2023/0287

Proposal: Two Story Extension

Site address: 5 Park View Road, Staincross, Barnsley S75 6LD

12 PROPOSED FRONT ELEVATION
1 : 50

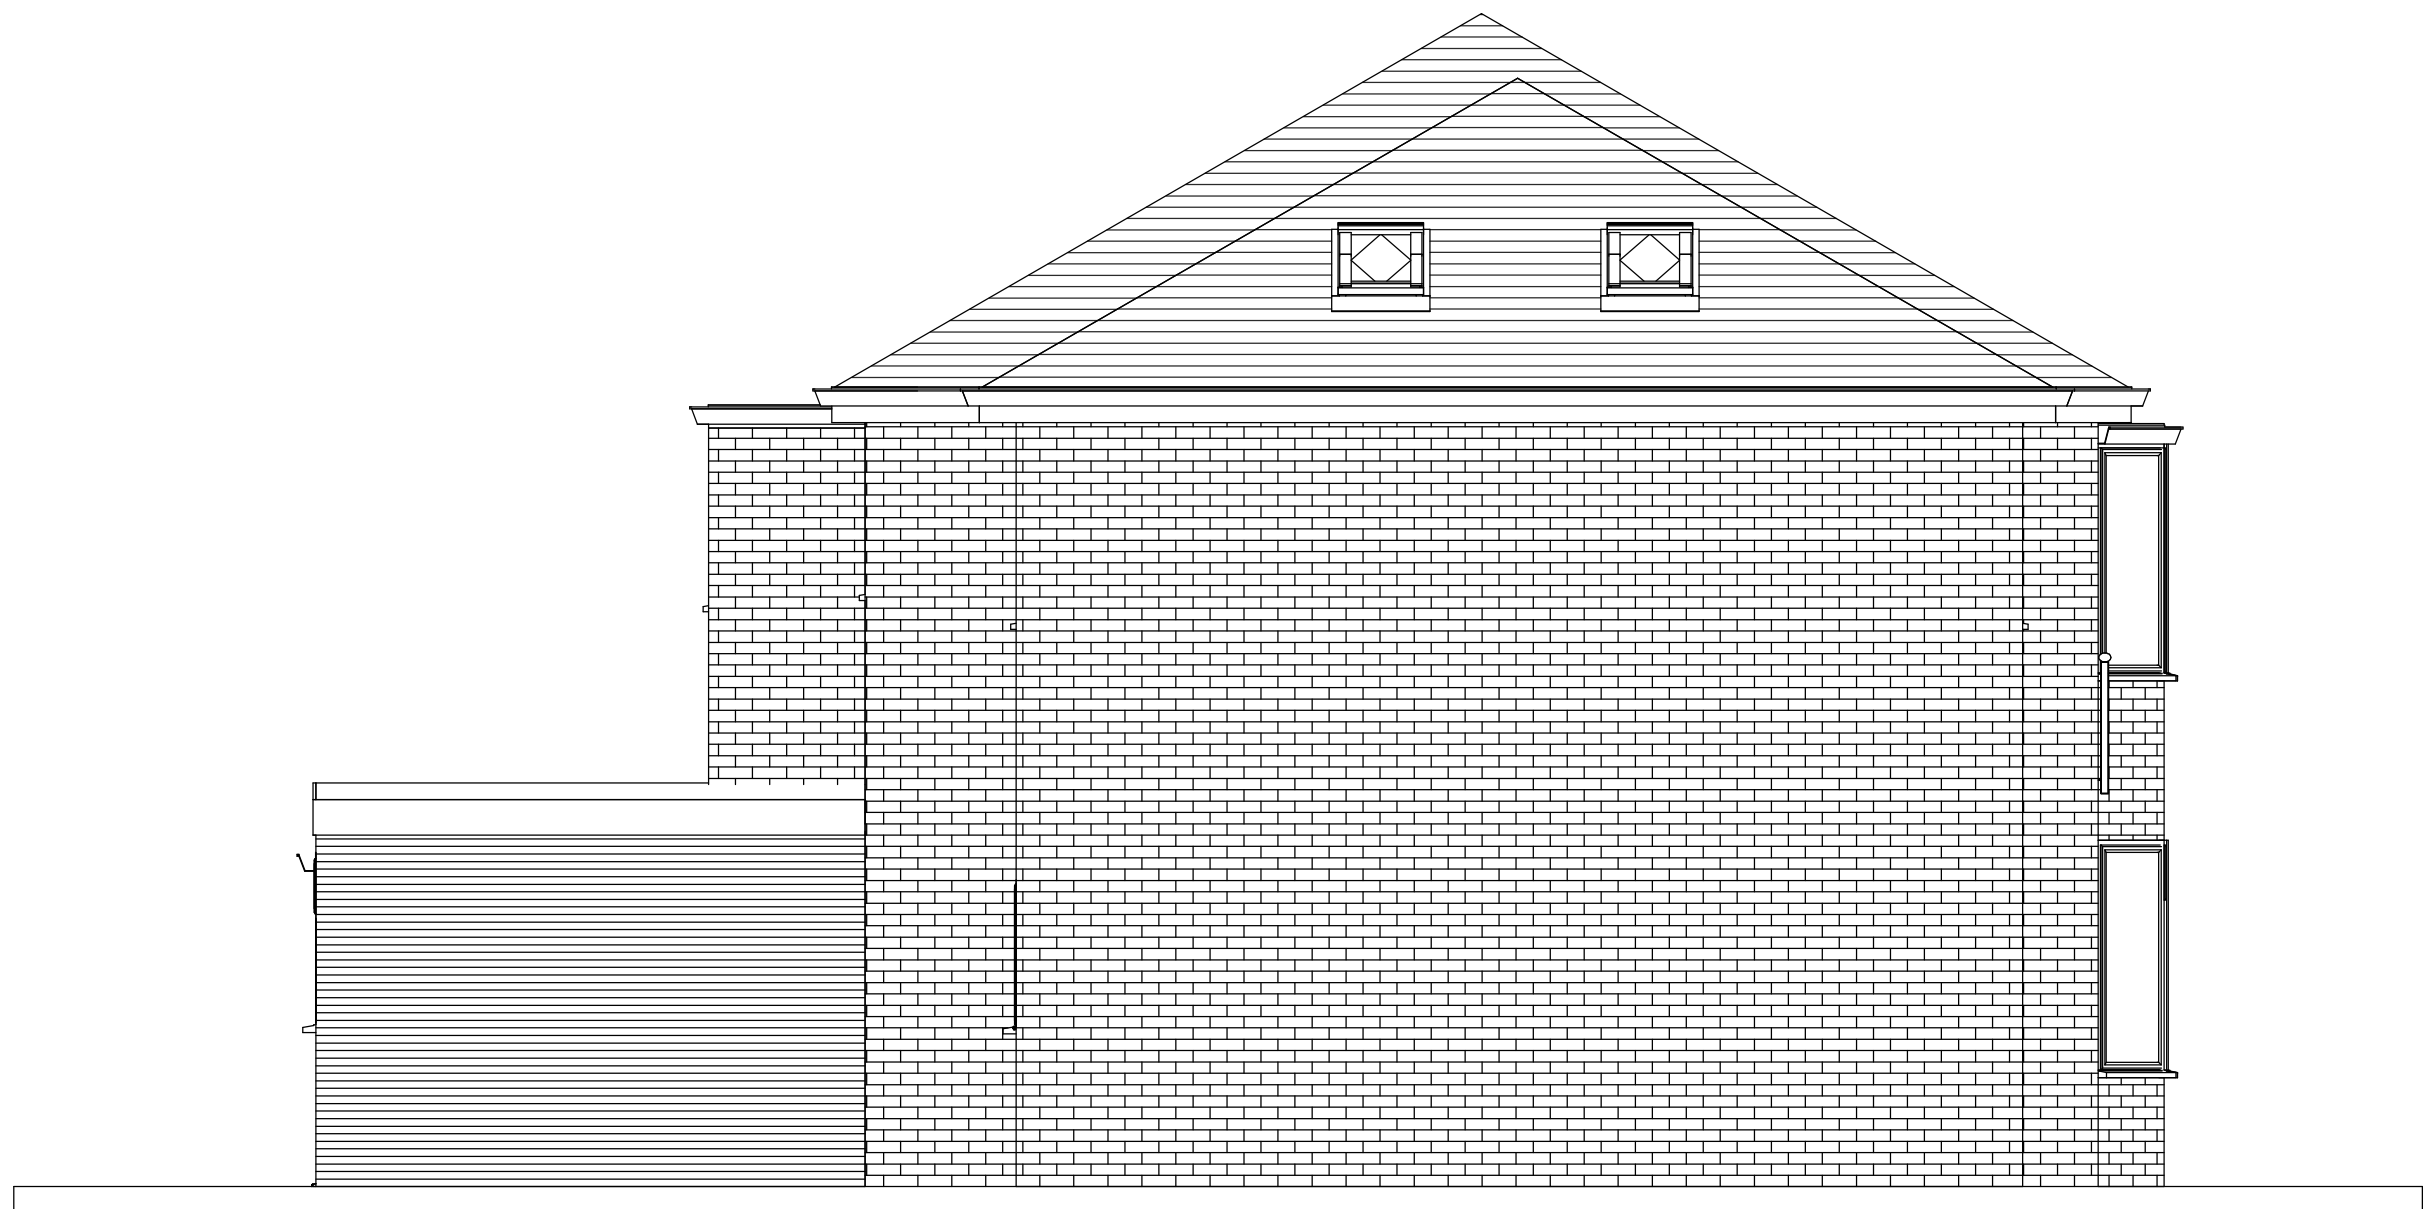
Visually, the proposed extension and Juliet style balcony does not have a significant impact in relation to the visual characteristic of the existing dwelling or the varied nature of the street scene. The proposed extension meets the local planning guidance set out in Household Extensions and Other Domestic Alterations. With no concern from Highways in relation to highway safety or Parking provision, there are no valid reasons to refuse the application.

13 PROPOSED SIDE ELEVATION
1 : 50

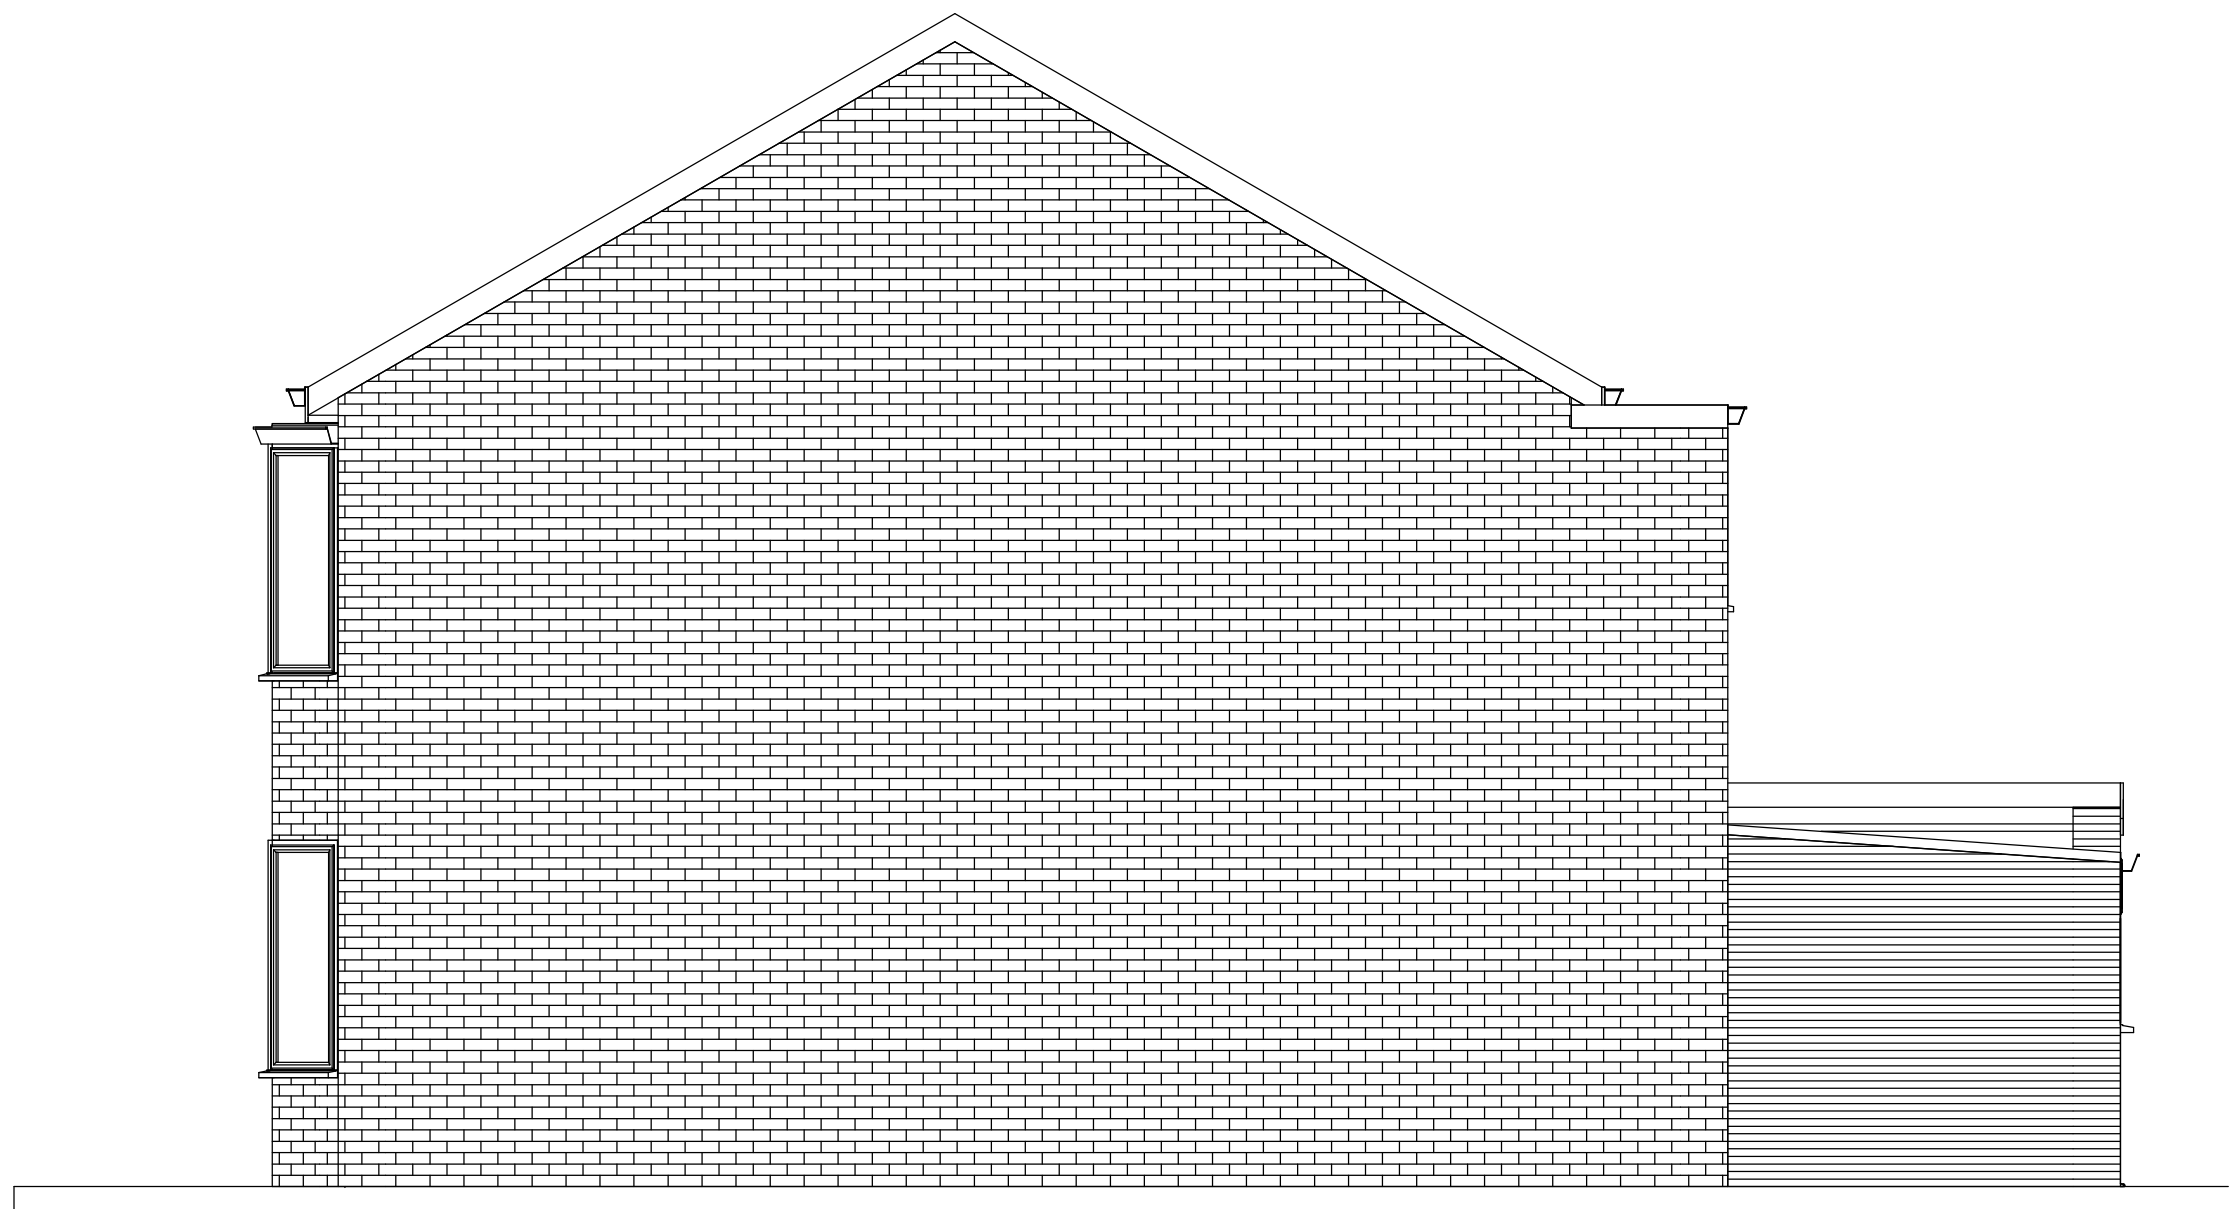
The blank elevation is not ideal but to protect the privacy of No. 4,, the blank elevation is required. It should also be noted that under permitted development rights a single storey extension along the length of the side of the dwelling could be erected up to 4m in height the impact of which would not be sis-similar to the proposed development. Additional privacy measures are to be achieved by the removal of three windows and an external door, from the current side elevation which currently sit further back from the boundary, but all looked and opened on to the side elevation of No.4 where a bathroom and bedroom are located. The proposal at No.5 only has two roof lights which would not intrude on privacy of the neighbours, along with a window on both the front and a rear elevation and rear back door. Due to the closeness of the proposal to the boundary treatment, entry passing by number No.4 will be restricted as the rear door only allows access into the rear garden. Residents, visitors, and vehicle access would no longer be able to pass by, congregate or

1 SITE PLAN
1 : 500

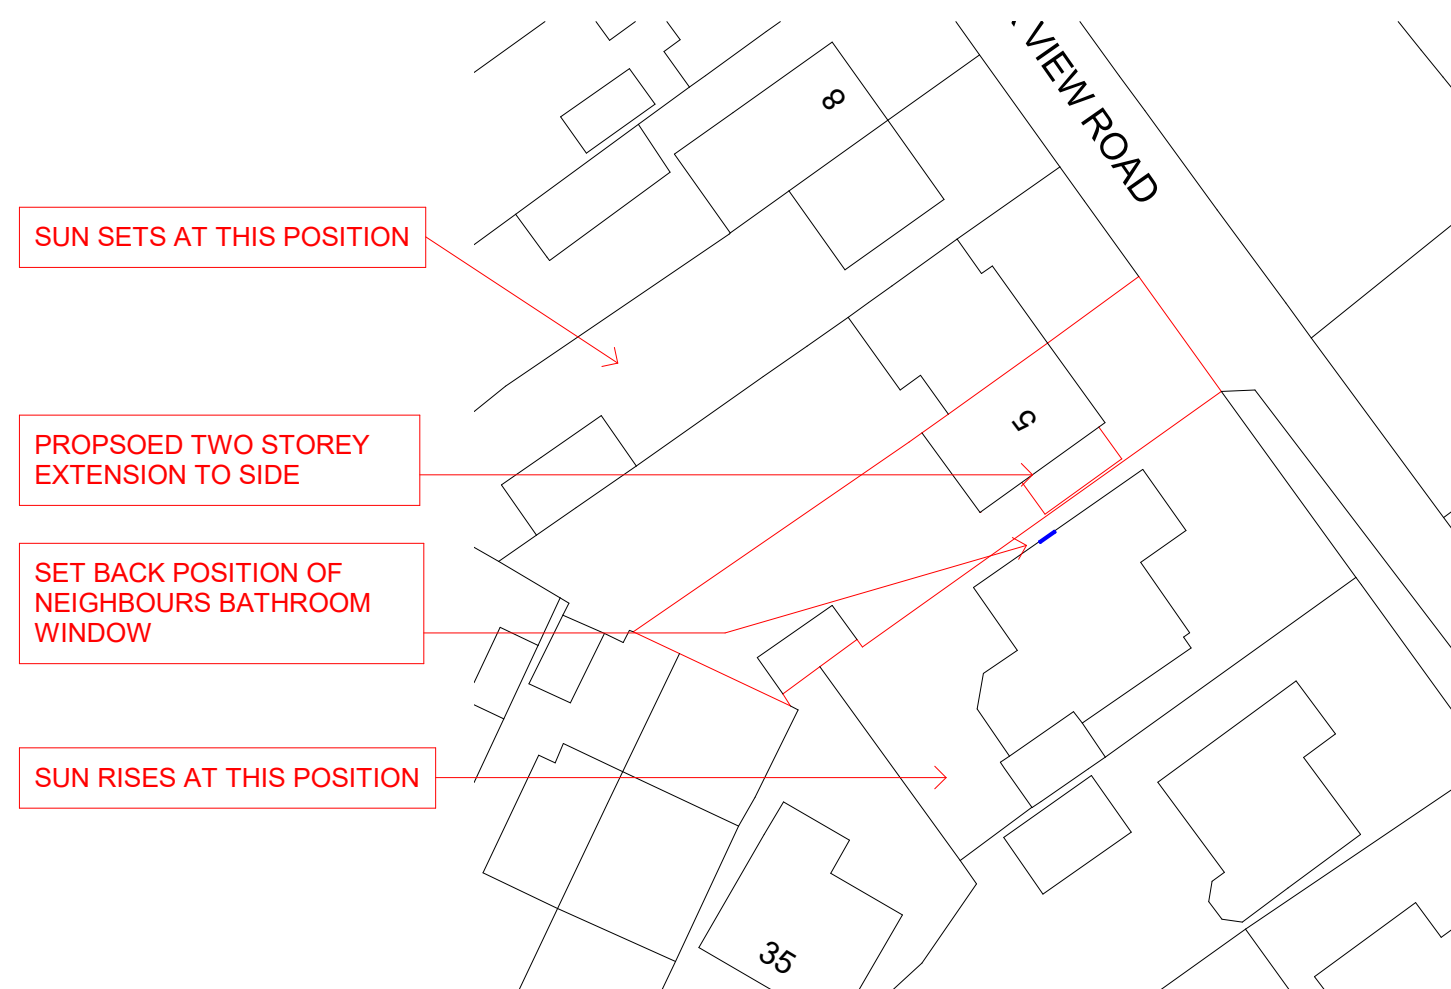
Properties to the front and rear of the dwelling are far enough away from the development not to be affected. No.6 Park View Road is also unaffected as the applicant's house screens them from the extension. The main property affected, as was the case in the previous application, is No.4 Park View Road. As can be seen from the plans below, the extension has been reduced to now pull it away from being in front of the neighbour's side bedroom window.

In this application, consideration has been given to concerns which led to a previous planning application being initially refused and subsequently dismissed at an appeal. The major concern was upon the amenity of the neighbouring dwelling at No.4. The principal concern was the partial or full coverage of the side bedroom window of No.4 in relation to the proximity of the proposed extension. New plans and elevations confirm that with a 1m reduction in in length, the new proposal would not wholly or partially cover the existing side bedroom window of No.4, thus not blocking the somewhat already restricted view of No.4.
